Road Safety Audit Report

Incorporating
Stage 1/2 Completion of Detail Design;
Design Organisation Response to items raised.

Proposed Works to existing Public Footpaths through Meadow Gardens, North End Road Yapton

Report Title:	Stage 1/2 Road Safety Audit
Date:	March 2021
Document reference and revision:	RSA-20-193-3
Prepared by:	Fenley Road Safety Limited
On behalf of the Overseeing Organisation:	West Sussex County Council
Design Organisation:	i-Transport LLP
Project Sponsor:	Redrow Homes Ltd

PUBLIC RIGHT OF WAY SURFACE DETAILS:

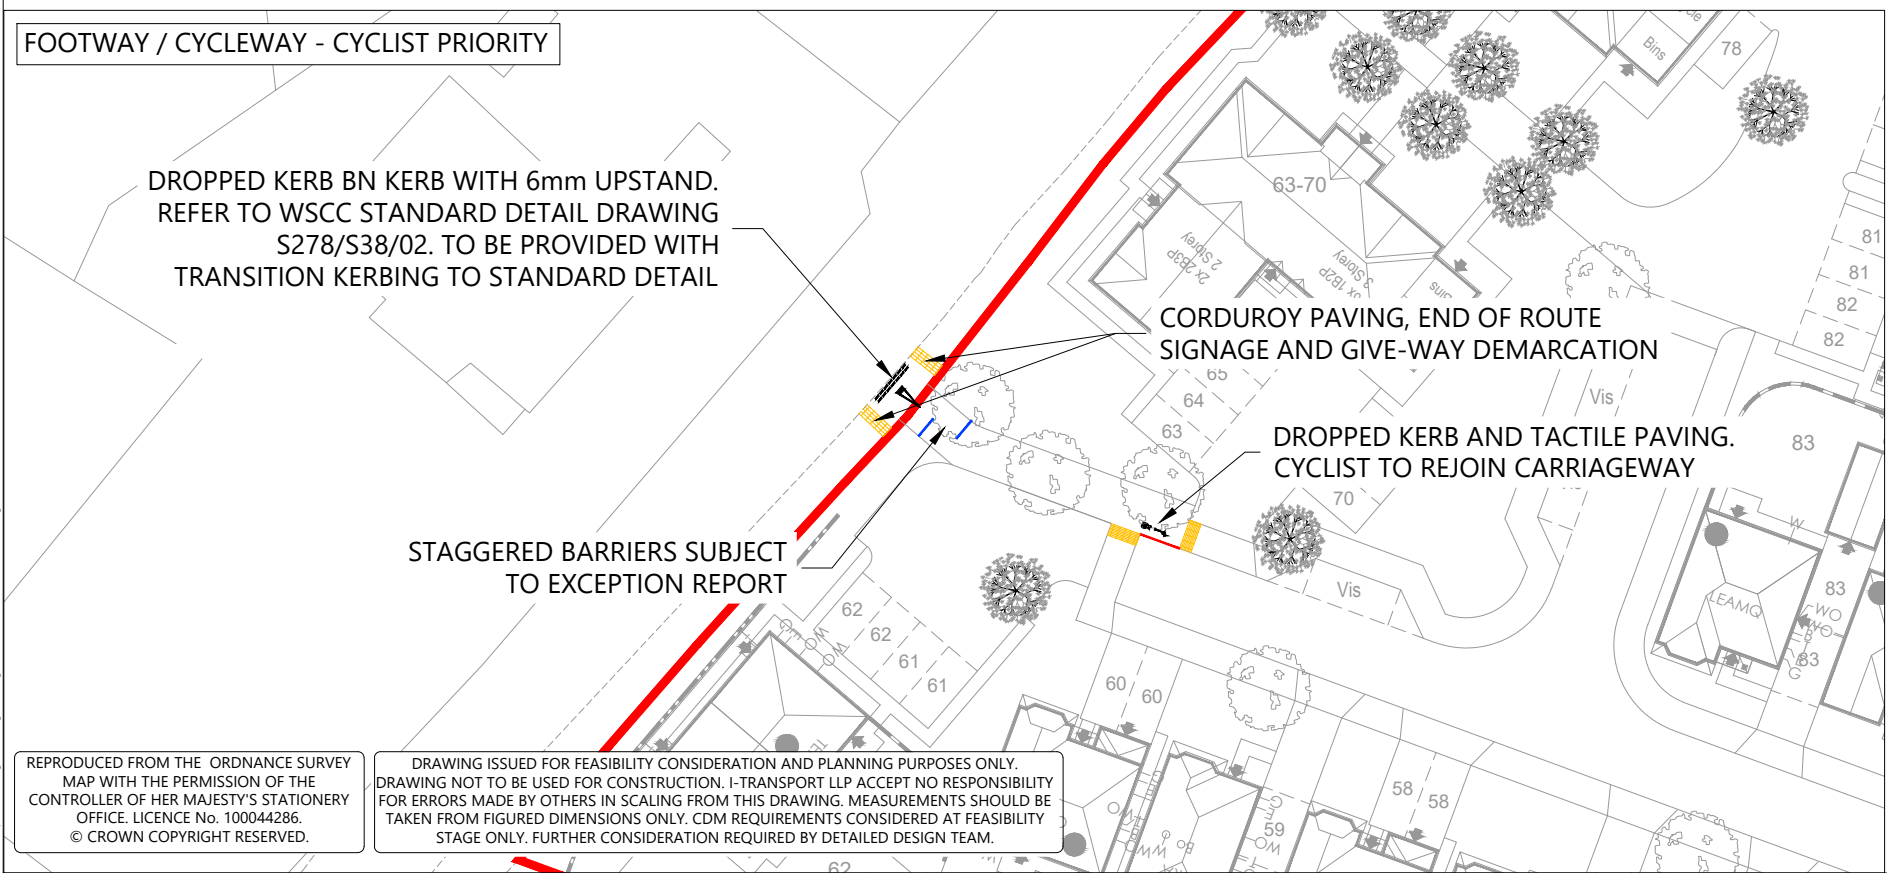
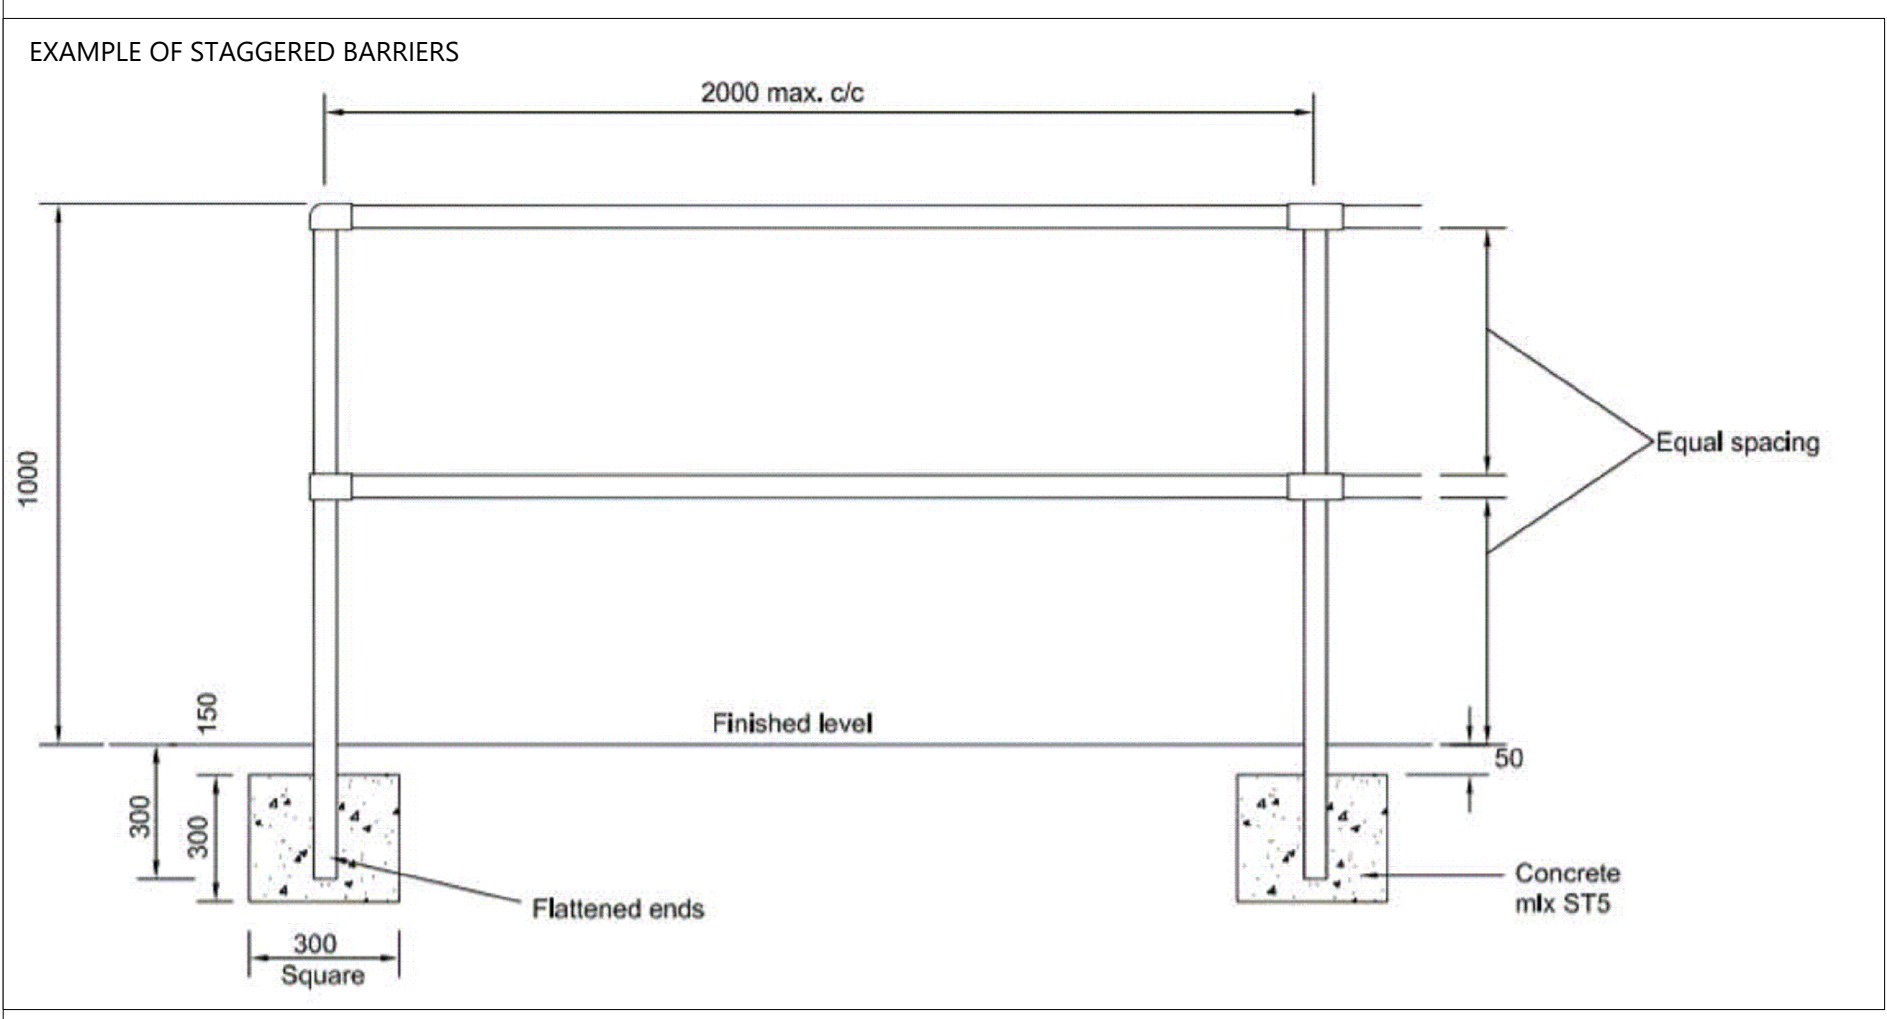
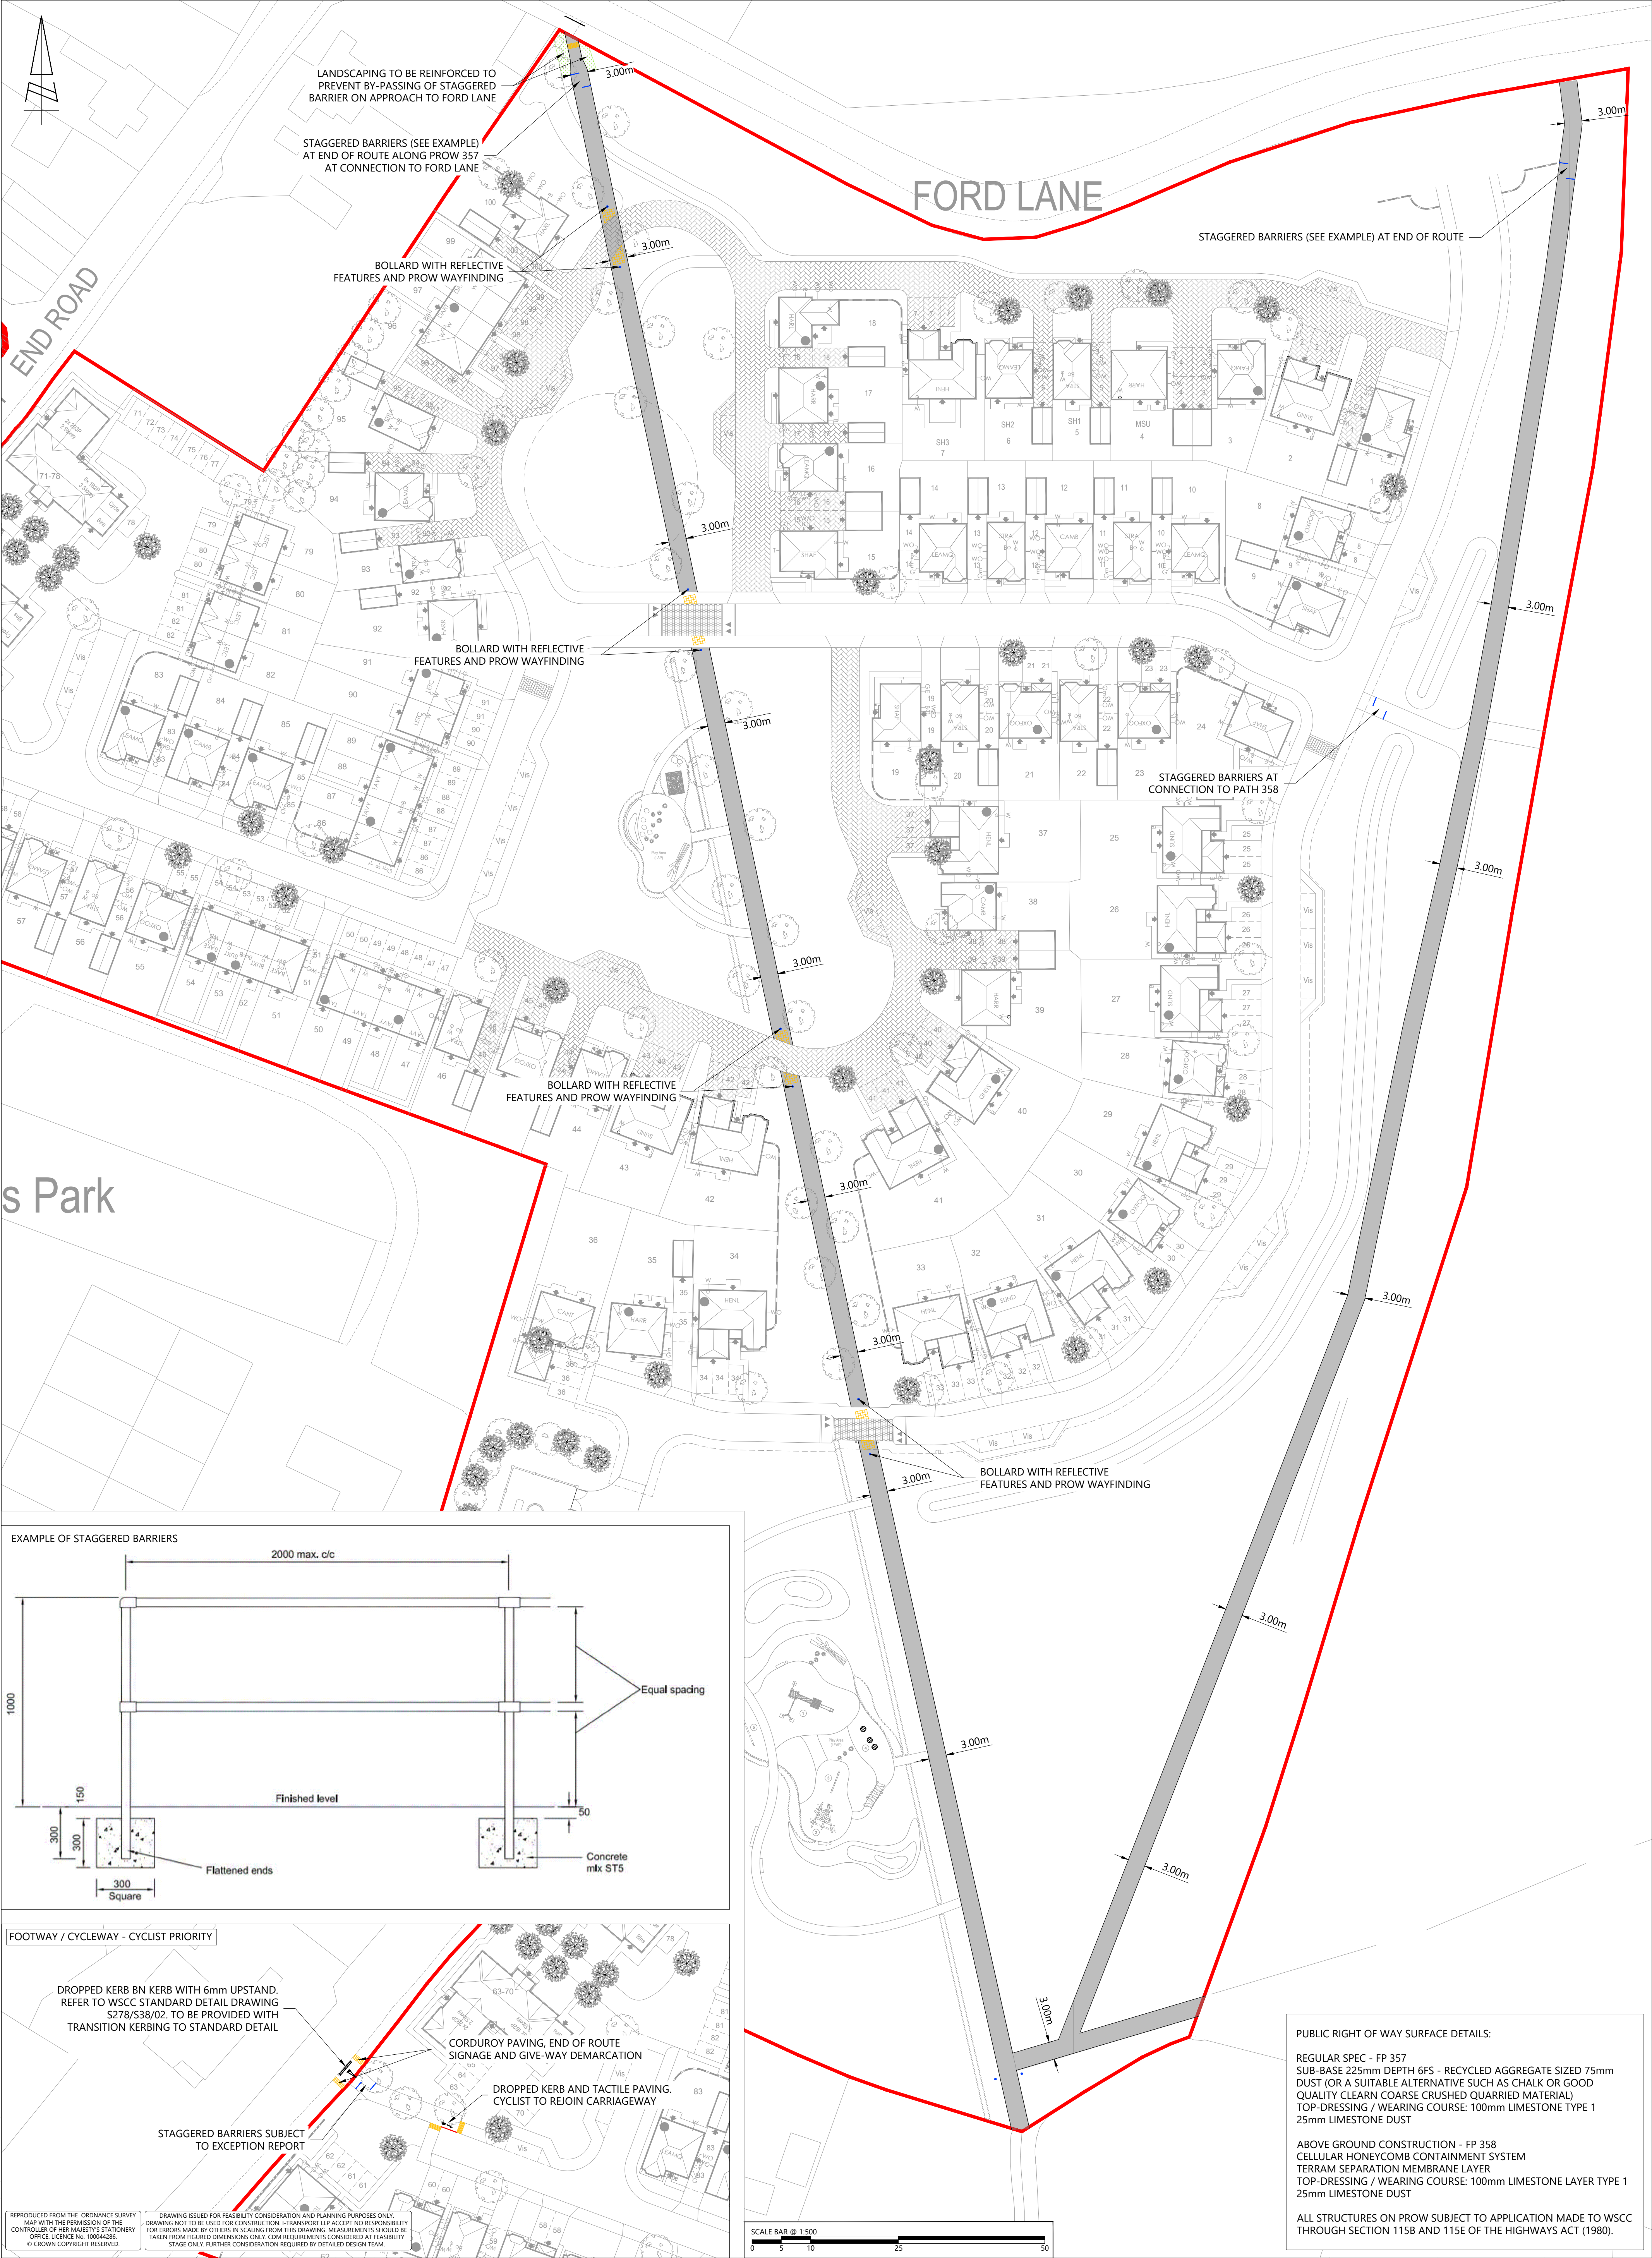
B.1	LOCAL ALIGNMENT
	<i>No Road Safety Concerns regarding LOCAL ALIGNMENT have been raised at this stage</i>
B.2	GENERAL
B.2.1	PROBLEM
Location:	Northern section of PROW 357
Summary:	Scheme encourages cyclists to travel down a steep set of steps
Acc Type:	Cyclist fall and vehicle cyclist collision
Footpath 357 forms a public right of way that currently passes between the southeast and northwest extents of a field meeting footpaths 358 and 359 to southeast and Ford Lane to the northwest. The field is set above the level of the Ford Lane carriageway with access gained via a set of 6 uneven concrete slab steps with a wooden handrail, up the grass embankment. The Audit Brief that has been supplied to provide sufficient information to undertake this Stage 1/2 Road Safety Audit, states that the connections between the site and existing rights of way which are outside the redline boundary, are outside the scope of the Audit and that the current proposals are to provide footpaths within the application site. However, it is understood that there are aspirations to upgrade footpath 357 to a footway cycleway. Whilst the existing connection between the footpath and Ford Lane allows pedestrian to walk up steps that are currently substandard and result in a pedestrian stepping straight onto the carriageway, the use of the connection by cyclists would result in the requirement for a bicycle to be transported up / down steps and could lead to cyclist falling and a personal injury or falling into the Ford Lane carriageway into the path of a vehicle resulting in a vehicle cyclist collision.

RECOMMENDATION:	
It is recommended that the northern most section of footpath 357 is reduced to 2 metres and measures are provided to deter use by cyclists with landscaping / planting provided either side of the staggered barriers to ensure that cyclists cannot bypass the measures.	
Location Plan:

The existing footpath 357 that passes through a field to the east of North End Road and south of Ford Lane in an unmade and narrow route that is uneven in places. The proposals subject to this Stage 1/2 Road Safety Audit include the widening of the existing footpaths to 3 metres and the reconstruction with a 225mm base course below 75mm of dust and 100mm of limestone type 1 topped with 25mm of limestone dust which will provide an adequate surface that is cambered to ensure surface water drains to the soft verges either side that are detailed on the landscaping plans associated with the approved application Y/112/20/DOC. The current proposals illustrated on dwg ITB16479-GA-002 revision B included with the Audit Brief, identifies that staggered barriers are to be provided adjacent to all locations where the public right of way crosses the on-site roads. The scheme drawing also identifies that raised tables or shared surface areas are to be provided where the footpath crosses the on-site roads and the landscaping plans indicate that the crossings are to be fairly open with no high-level planting provided in close proximity. Whilst staggered barriers assist in slowing users to ensure that they proceed with caution, users tend to bypass the measures if a route is available. It is therefore likely that users of the public right of way, will bypass the staggered barriers on the adjacent soft verge which is likely to become uneven as a result of use particularly during inclement conditions. An uneven surface could give rise to trips, falls and personal injury.

It is recommended that the staggered barriers are replaced with bollards that include reflective features to reduce the likelihood of users bypassing the surfaced route and crossing at a location away from the dropped kerb crossing points that benefit from tactile paving.

Accepted – the width of the footway has been narrowed to 2m and landscaping features have been identified on either side of the path/barrier to prevent by-passing of the infrastructure. The revised design is presented in drawing ITB14679-GA-002 Rev C.

DESIGN ORGANISATION RESPONSE provided by i-Transport on the 23 rd March 2021 following formal issue of this Stage 1/2 Road Safety Audit on the 22 nd March 2021	
Accepted – the staggered barriers have been removed from the internal aspect of the layout and replaced with bollards. The bollards are to be fitted with reflective material, and also incorporate way-finding for the Public Right of Way.	
B.3	JUNCTIONS
	<i>No Road Safety Concerns regarding JUNCTIONS have been raised at this stage</i>
B.4	WALKING CYCLING AND HORSE RIDING
B.4.1	PROBLEM
Location:	Scheme
Summary:	Users will travel around the proposed staggered barriers on uneven ground
Acc Type:	User trip and fall
The proposals that are subject of this Stage 1/2 Road Safety Audit include the provision of a surfaced 3 metre route for pedestrians through a proposed development between footpath 358 and Church Lane to the south and Ford Lane to the north as illustrated on dwg ITB16479-GA-002 revision B included with the Audit Brief. The proposed route is to cross the on-site roads that are to facilitate vehicular access, a number of times with two crossing of shared surface areas and two crossing of general carriageway where the crossing point is to be provided on a raised table. Each of the crossing locations is in-line where pedestrians walk towards the carriageway and are to consist of dropped kerbs that are understood to include an upstand of between 0 and 6mm and benefit from tactile paving. However, as illustrated on the scheme drawings, a minimum of two rows of tactile paving slabs are to be provided allowing for a minimum depth of 0.8 metres. Pedestrians could step across two rows of tactile paving and as such, visually pedestrians could enter the carriageway without warning. The crossing points are to be provided at shared surface areas or where raised tables are provided and as such, vehicles should be proceeding with caution at a low speed, however, a pedestrian entering the carriageway and the path of a vehicle without warning, could lead to vehicle pedestrian collisions. Furthermore, no tactile warning surface is provided adjacent to the stepped access to Ford Lane which could lead to pedestrians falling down the steps into the carriageway
